Response to Planning Application

From: Arun District Council Greenspace

Application ref: AL/28/21/PL

Description: Demolition of 2 No. outbuilding & erection of 2 No 1.5 storey dwellings, detached garage block & associated scheme of hard & soft landscaping. This site falls within Strategic Site SP2, CIL Zone 1 (Zero Rated).

Drawing Title
Tree Constraints Plan

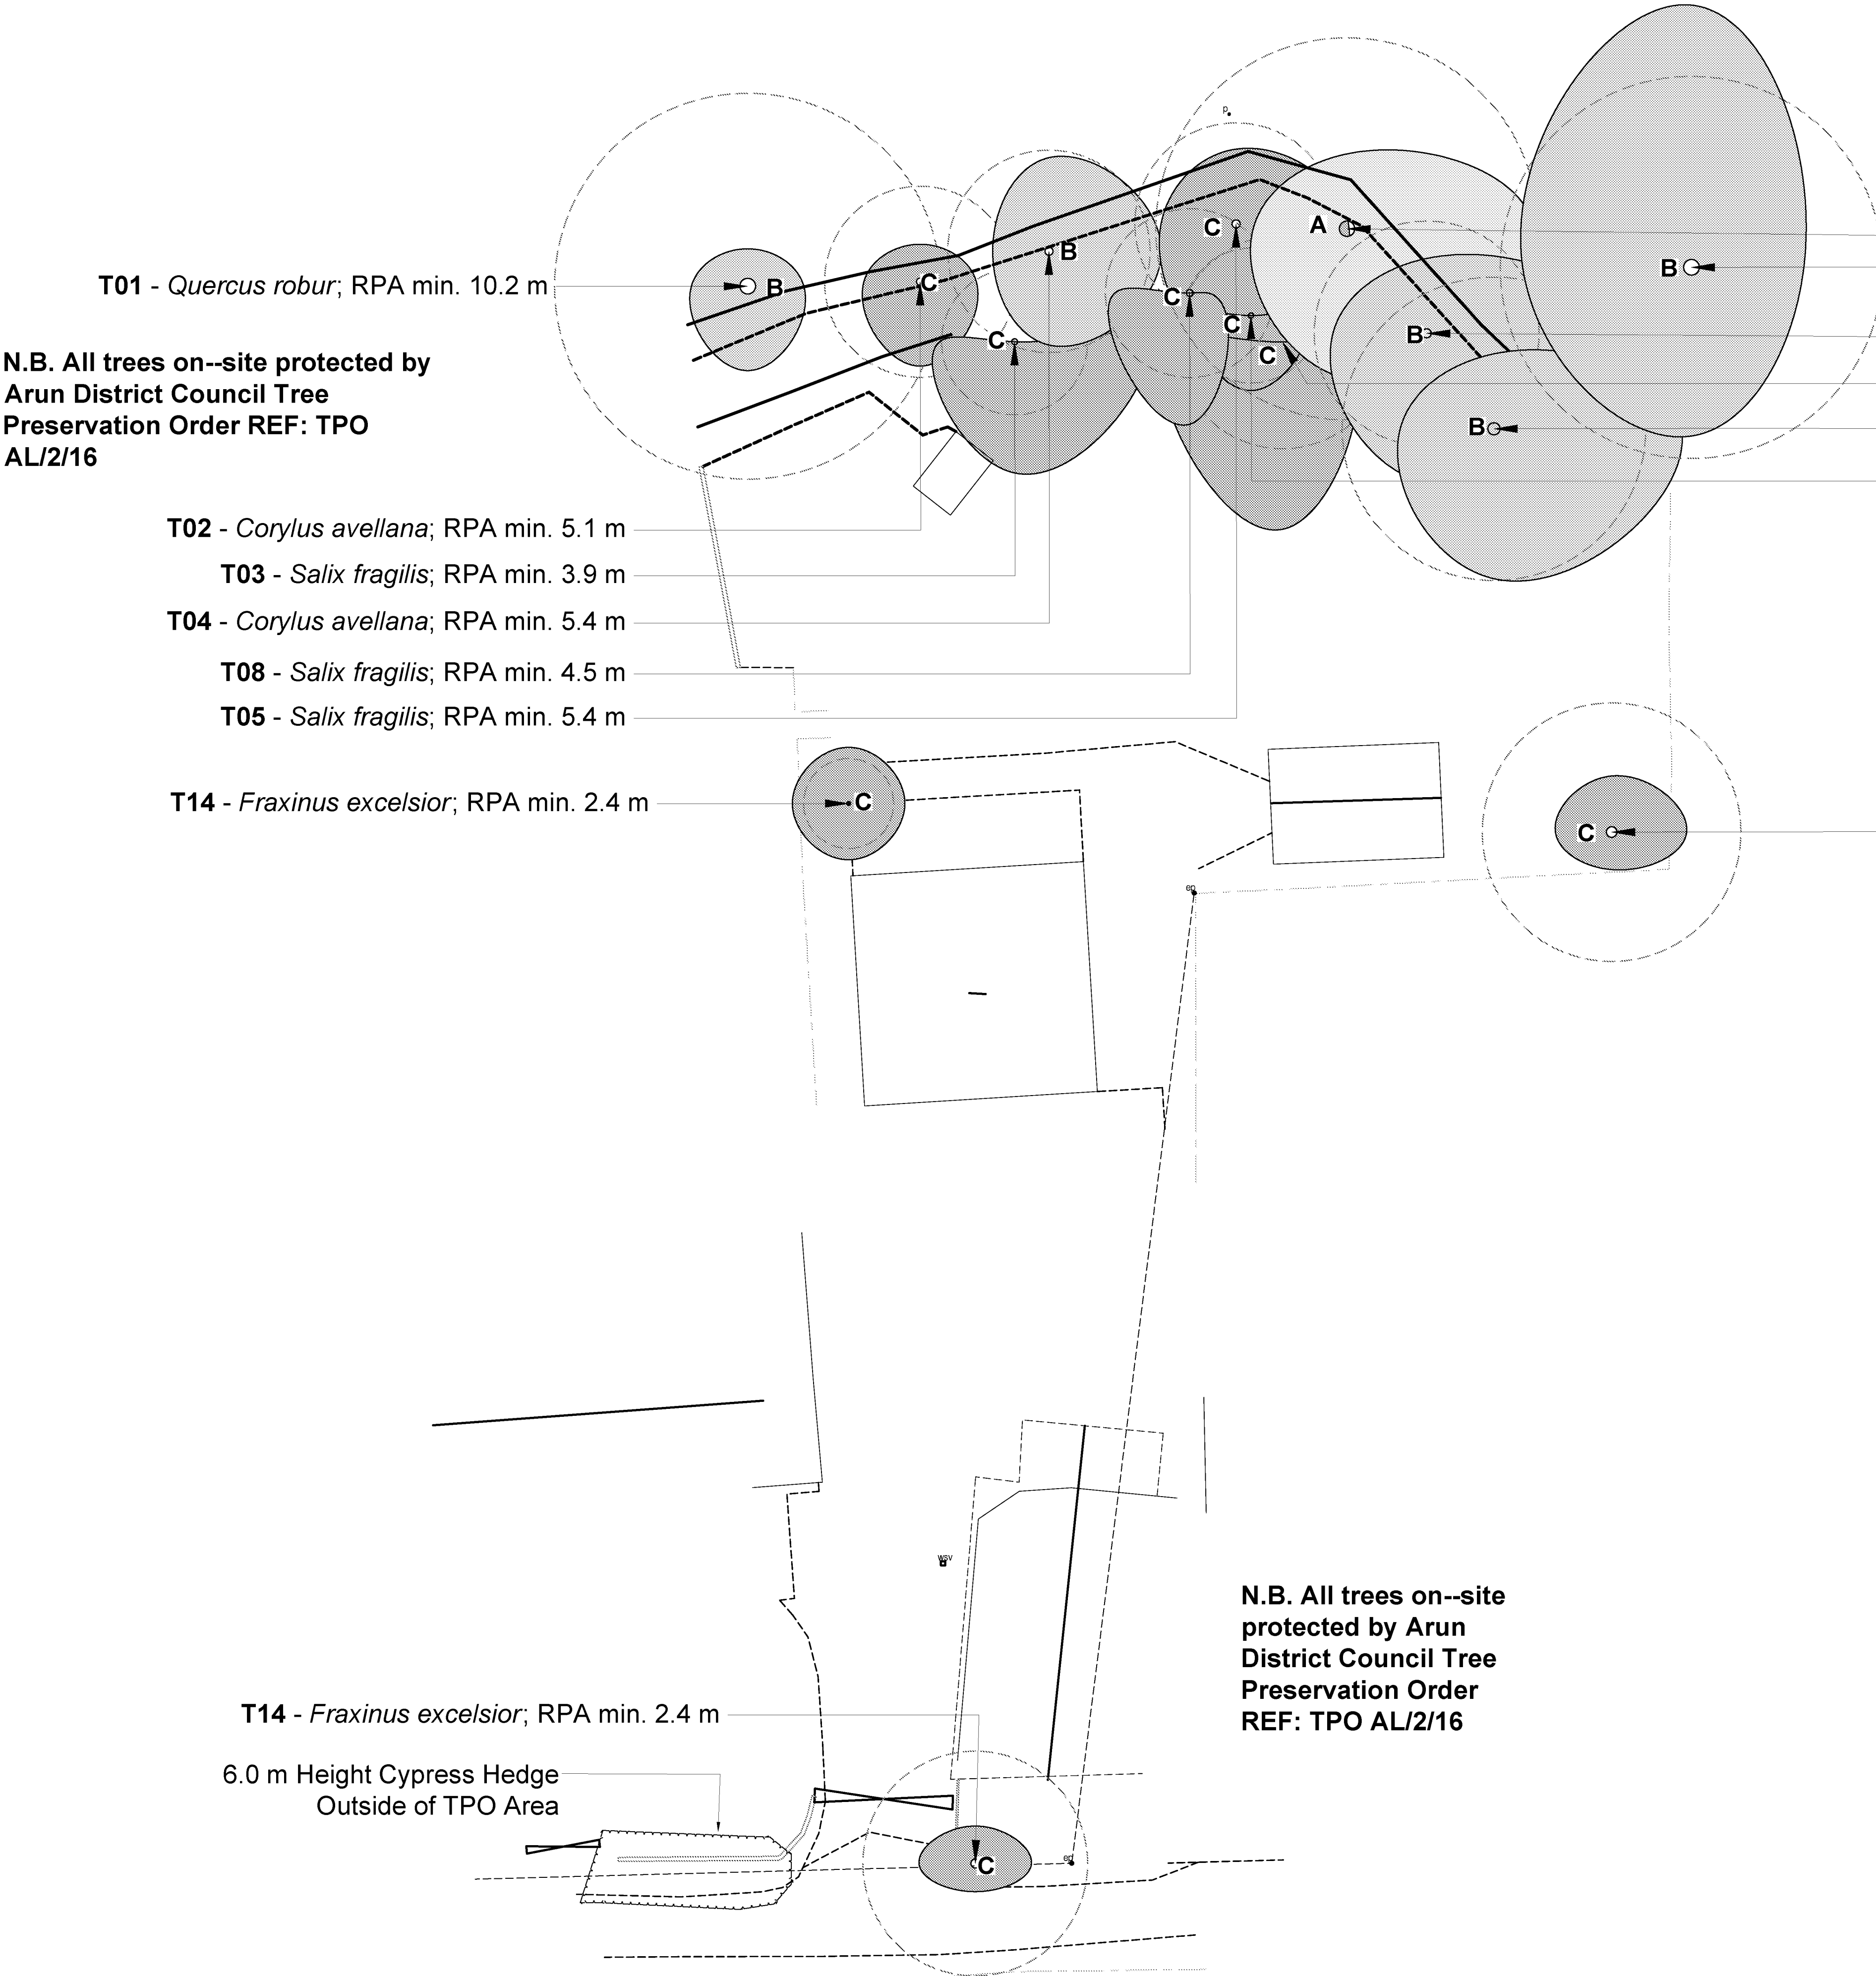
The indicative site layouts has made reference to TPO'd trees to be protected and retained throughout and along the northern boundary of the site, however there has been no detail of landscape mitigation provided for these new dwellings. These details will need submitting in the form of a detailed planting plan and specification detailing species choice, actual plant quantities, planting densities and size at time of planting. Native planting will need to be incorporated due to location in semi-rural setting.

Landscape provision to the dwellings will need to be confirmed along with the recommendation to provide screen/buffer planting as required. All proposed planting should be considered and its connection for biodiversity and habitat explored, with a biodiversity net gain following development. Trees specified should be at a size which allow instant impact, but which will establish and mature as the site develops.
